DECISION DELEGATED TO HEAD OF PLANNING

Application No: H16-1067-25 **Applicant:** Rollins Group

Proposal: Details of Biodiversity Gain Plan, BNG HMMP & Surface Water Drainage (Conditions 3, 4 & 5 of H16-0588-25)

Location: Pilgrims Europe Fulney Lane Spalding

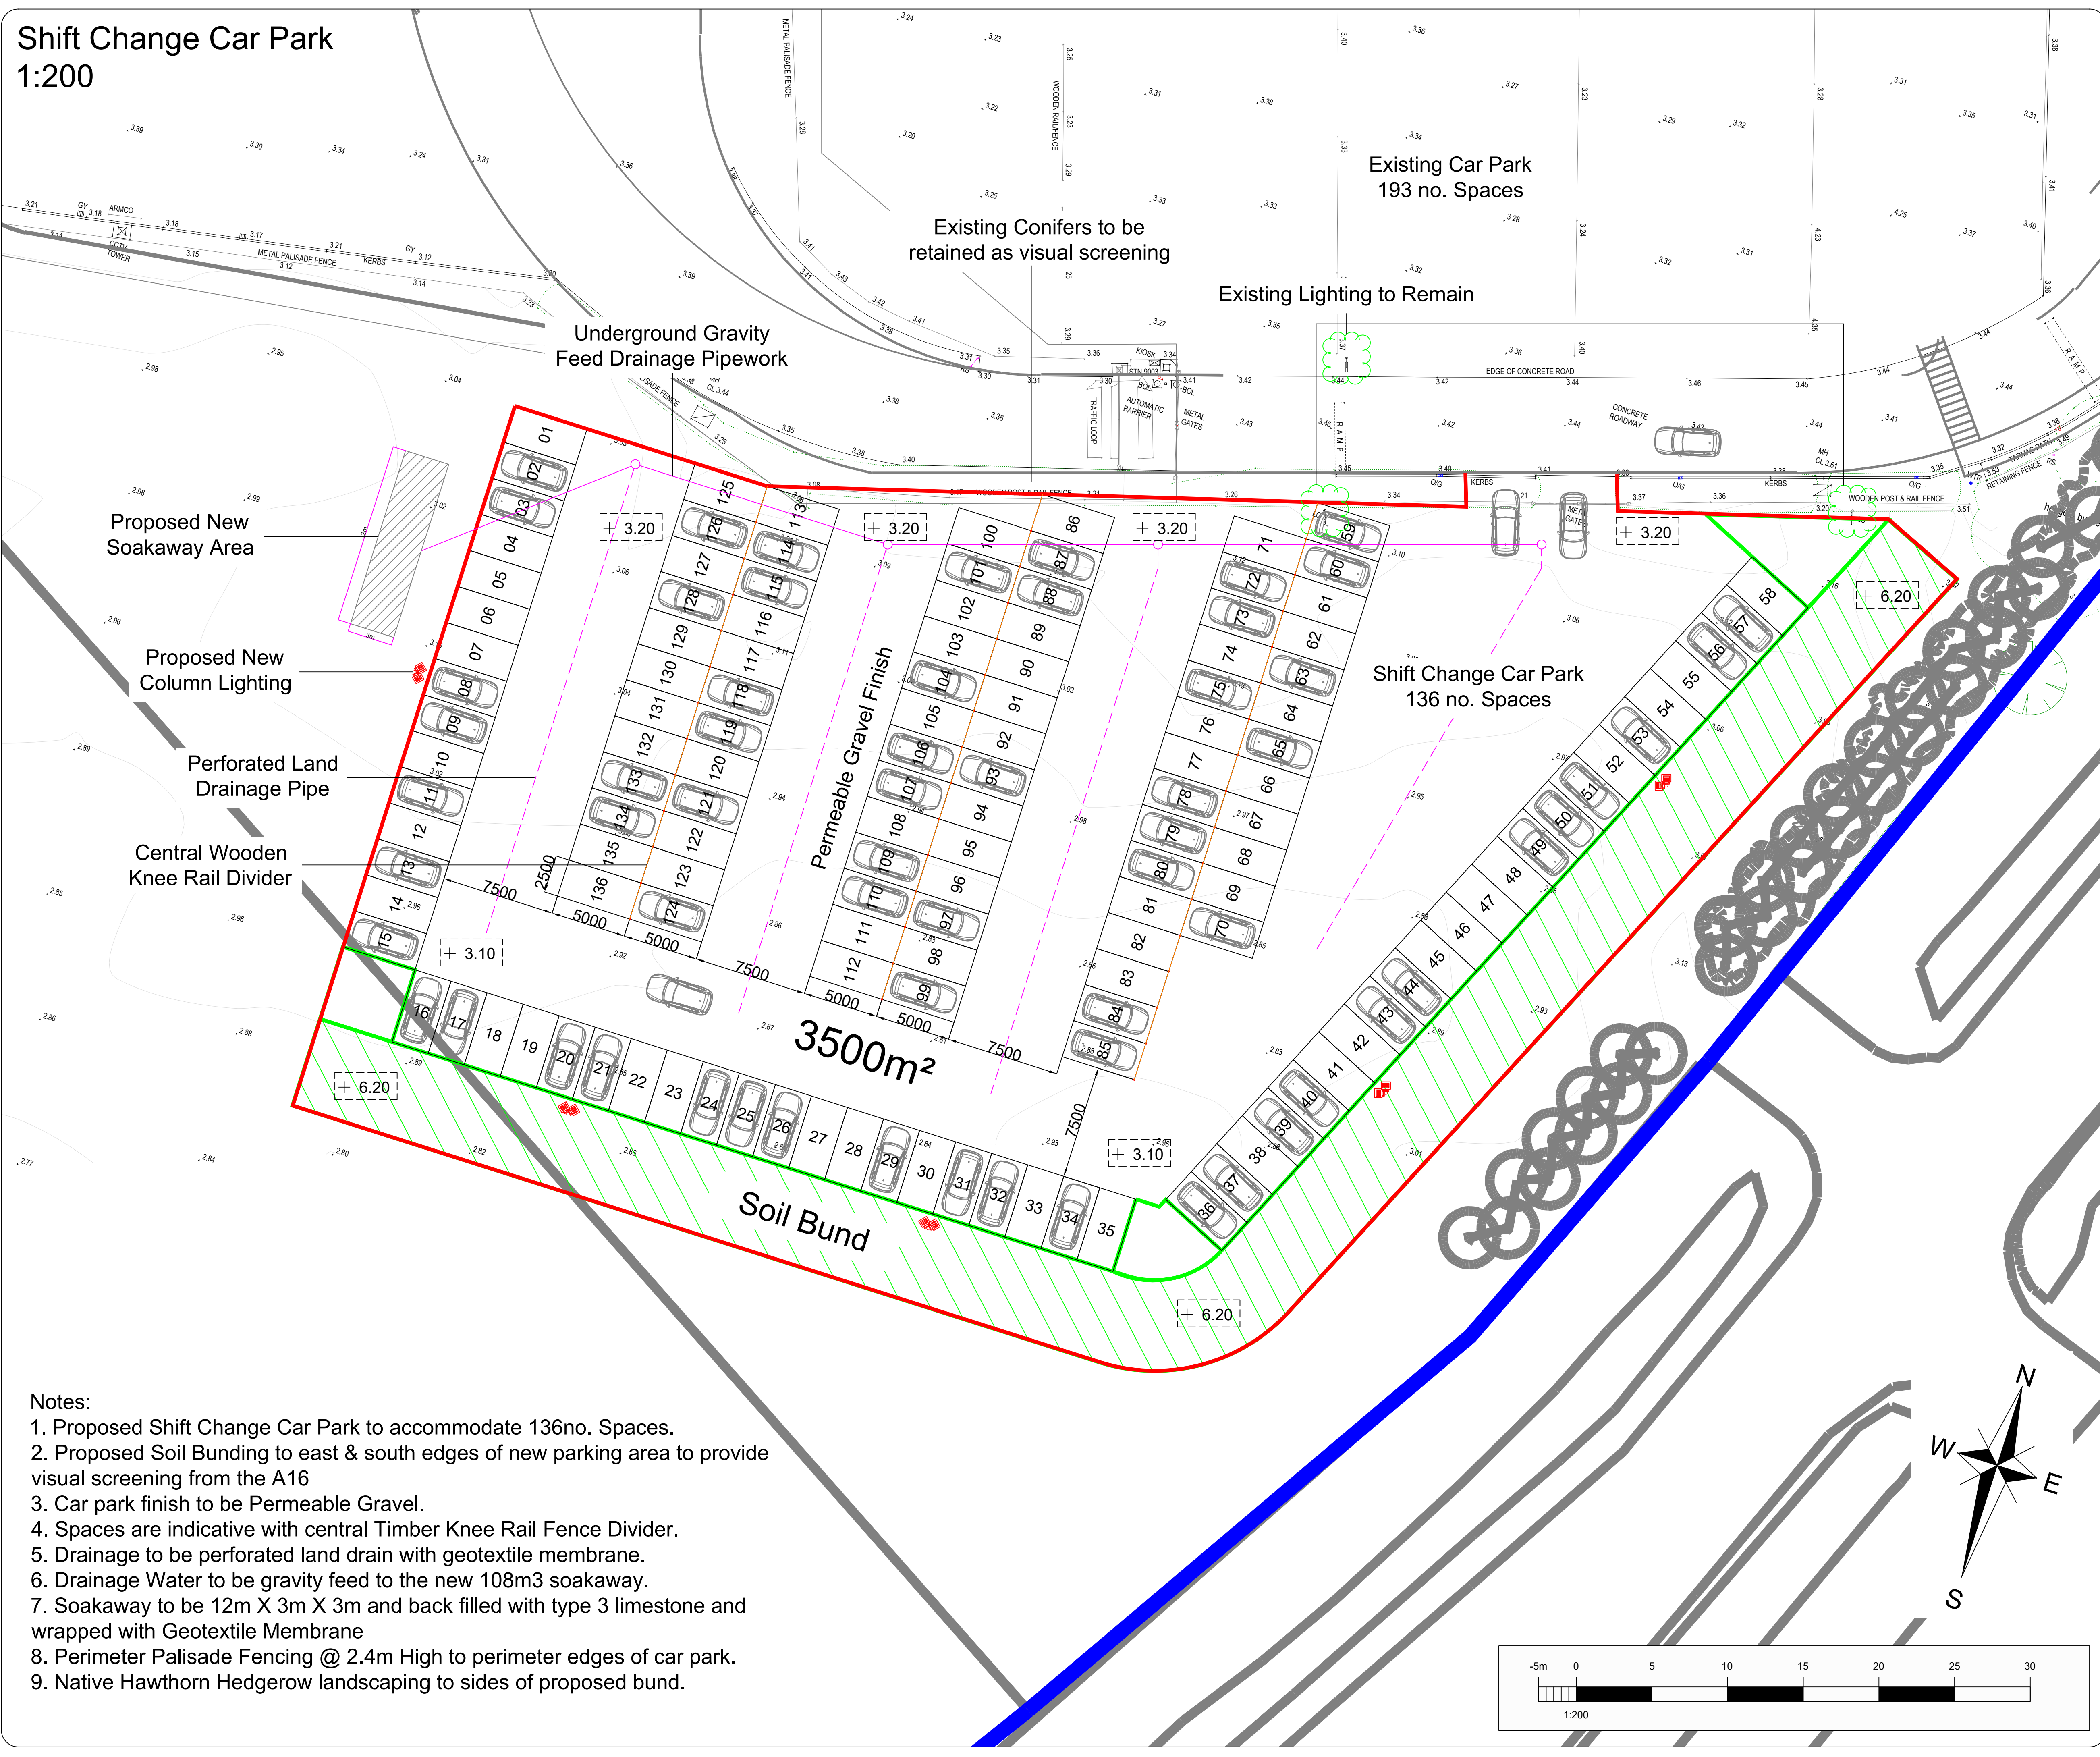
The applicant has indicated that they intend to dispose of surface water via infiltration, however I cannot see that the viability of this proposal has been evidenced. We recommend that ground investigation is carried out to determine infiltration potential, followed by testing in line with BRE Digest 365 if onsite material is considered favourable for infiltration.

If infiltration is not feasible at this site, following the drainage hierarchy we would expect the applicant to propose to discharge surface water to a watercourse. In this case, consent would be required under Byelaw 3. The Board recommend that any discharge is in line with the National standards for sustainable drainage systems (SuDS) published in June 2025. Further to the National Standards for SuDS, the Board's policy is to restrict discharges to 2l/s/ha or annual average flood flow rate (QBar or QMed), whichever is higher.

The IDB issued a holding objection relating to the lack of information on infiltration. Subsequently the applicant has provided these calculations, demonstrating feasibility. There has been no response from the IDB to a secondary consultation. It is considered given the lack of objection to the drainage strategy during the application process, and that the strategy is in line with the SuDs hierarchy that this approach which is now supported by technical detail is considered acceptable. The information is therefore sufficient to discharge.
